Recommendation Report for Planning Permission for Works or Extension to a Dwelling

REF NO: R/27/22/HH

LOCATION: West Hayne
19 Angmering Lane
East Preston
BN16 2TA

PROPOSAL: Installation of a detached garage.

Garage as proposed

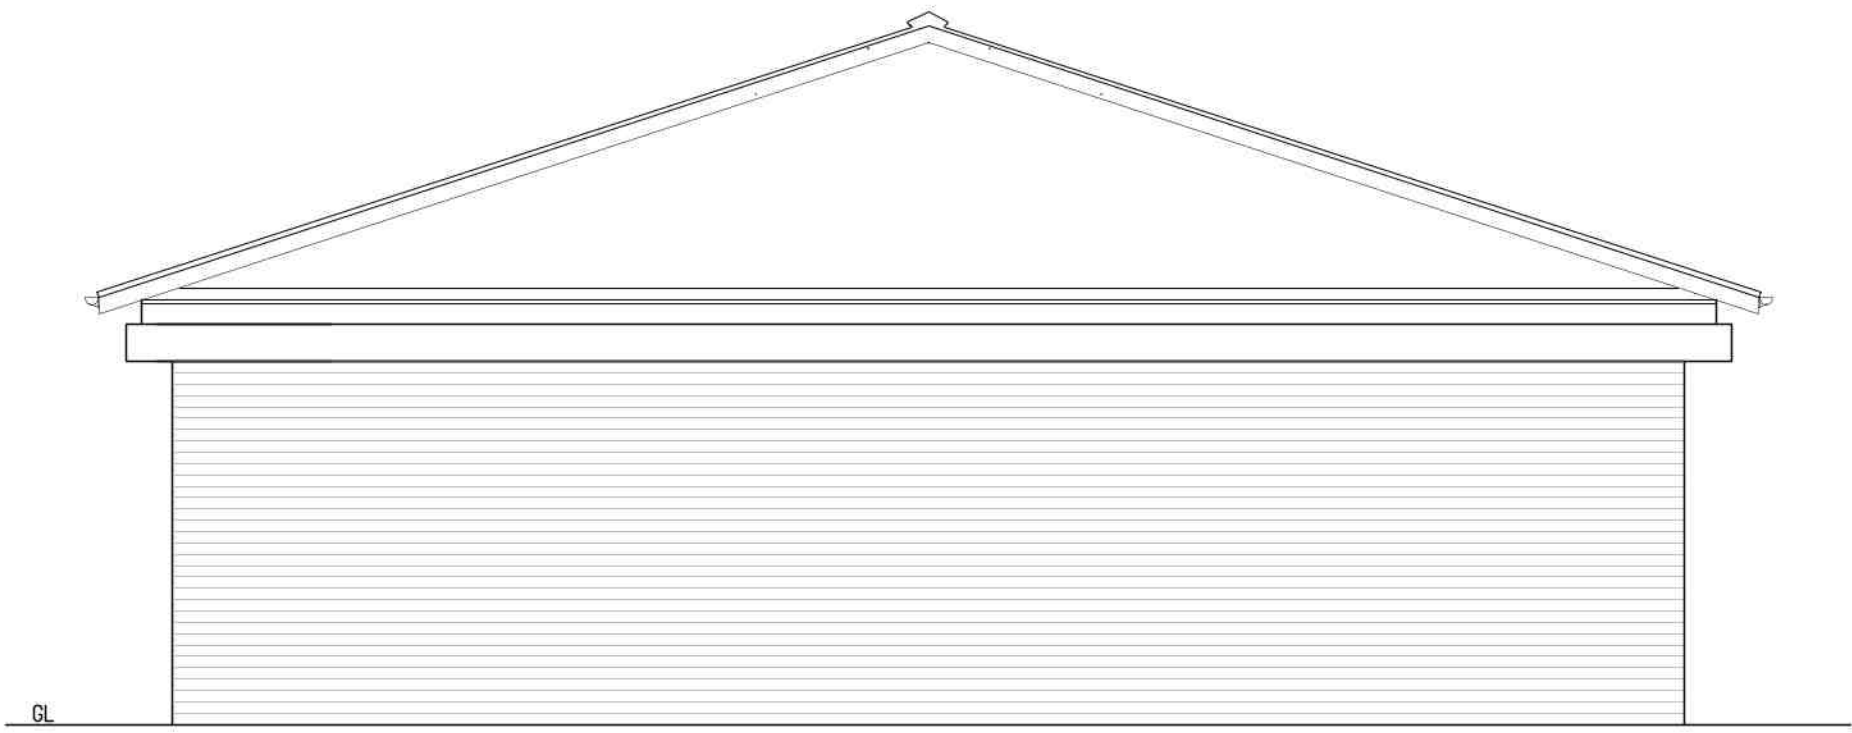
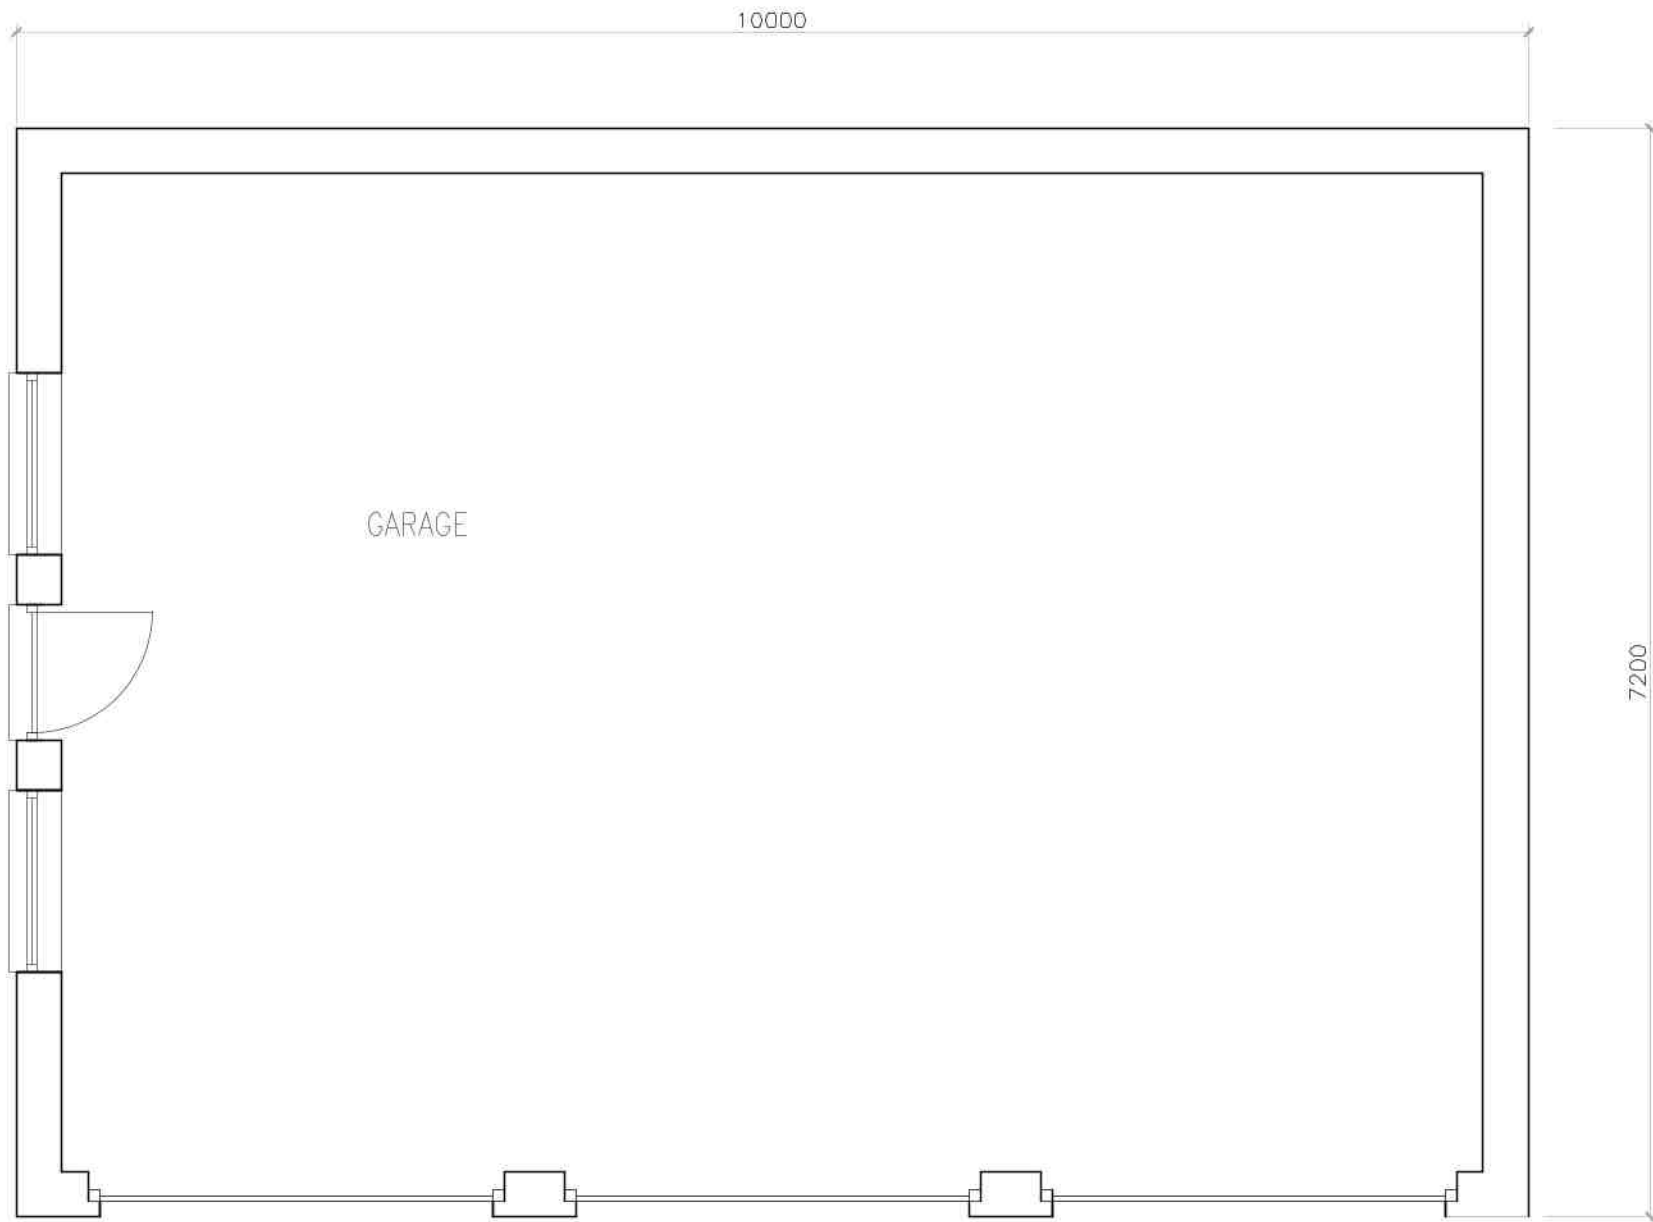
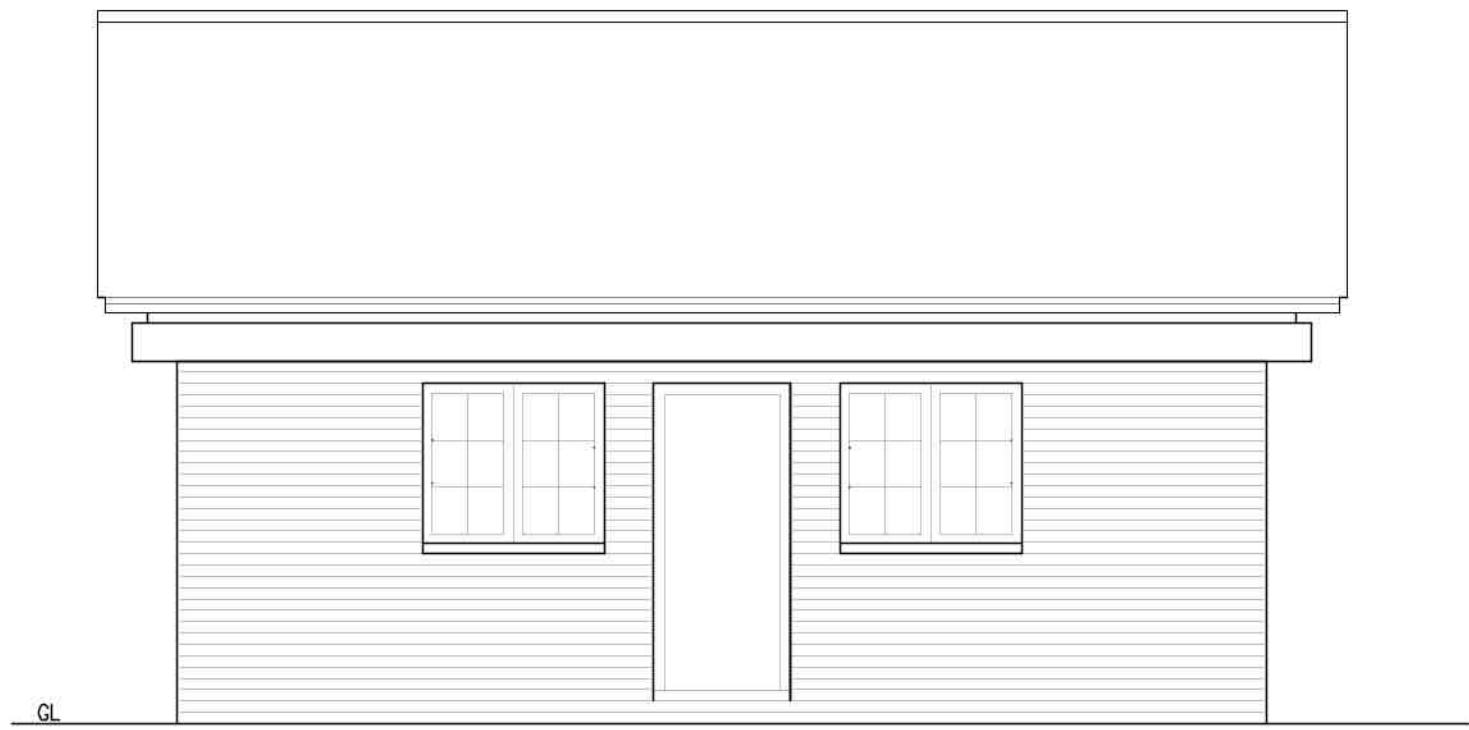
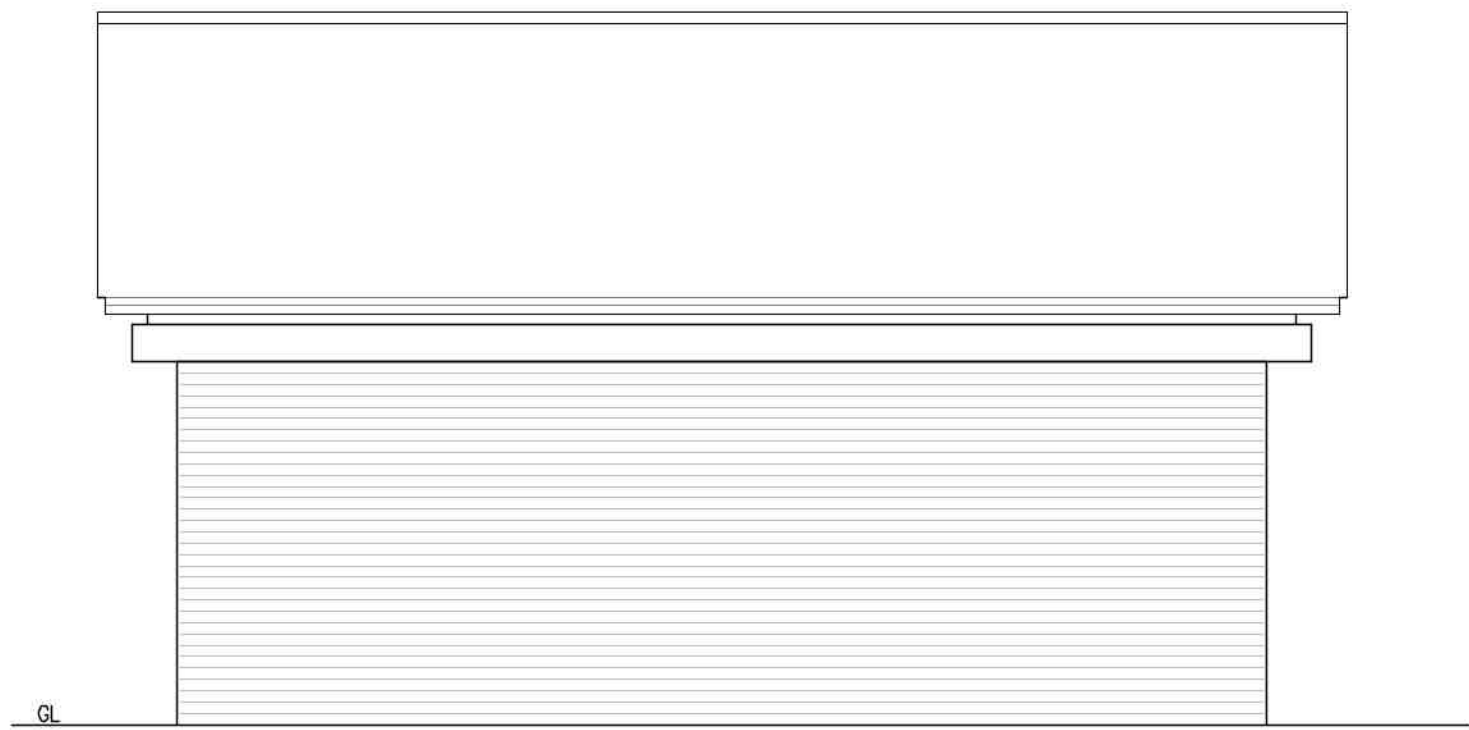
The scale of the proposed detached garage is large. It is to be 10m in width, 7.2 in depth and 4.7m in height at its peak. The roof design features rendered gable ends to the front and rear (East and West) and a shallow pitch design leaving the eaves overhanging by approx. 0.5m on all sides and at approx. 2.8m in height. This garage is to be sited in the North-West corner of the curtilage, separated from the North and West site boundaries by approx. 1.2m. The curtilage this property possesses is extensive and the garage would make efficient use of a corner of the plot that is currently unused without having any negative impact on the provision of private amenity space. The scale of the proposal is acceptable given the scale of the host dwelling and the curtilage.

The materials proposed for external finishings are brickwork walls, natural slate roof, rendered gable ends, metal garage door and a timber side door to the South elevation. These materials are considered appropriate and are in keeping with either the host dwelling or the locality.

Section I of the Arun Design Guide states that the internal floorspace of garages for 1 No. parking space should be 3m in width by 6m in depth. This garage provides 3 No. parking spaces with an overall internal floorspace of approx. 9.4m in width and 6.6m in depth. This is adequate space and appropriate.

Although the scale of the proposed garage is large, it remains of single storey, separated from the North and West site boundaries by approx. 1.2m and features a pitched roof design that lessens any impacts of overbearing on neighbouring properties.

The siting of the proposal is such that it is positioned to the rear of the East (side) elevation of the West neighbour properties rear garden. The rear gable end design of the proposal would mean that the peak height of the garage at approx. 4.7m would be present along the East elevation of this neighbour's rear garden. However, this garage would be approx. 16.8m from the rear of the West neighbour property. This, in combination with the separation of the proposal from the site boundary and its single storey nature, has led to the conclusion that it would not give rise to any significantly adverse impacts by way of overbearing or overshadowing on this neighbouring property. As aforementioned, there are no new viewpoints provided by this proposal and as such, there are no adverse impacts by way of overlooking.
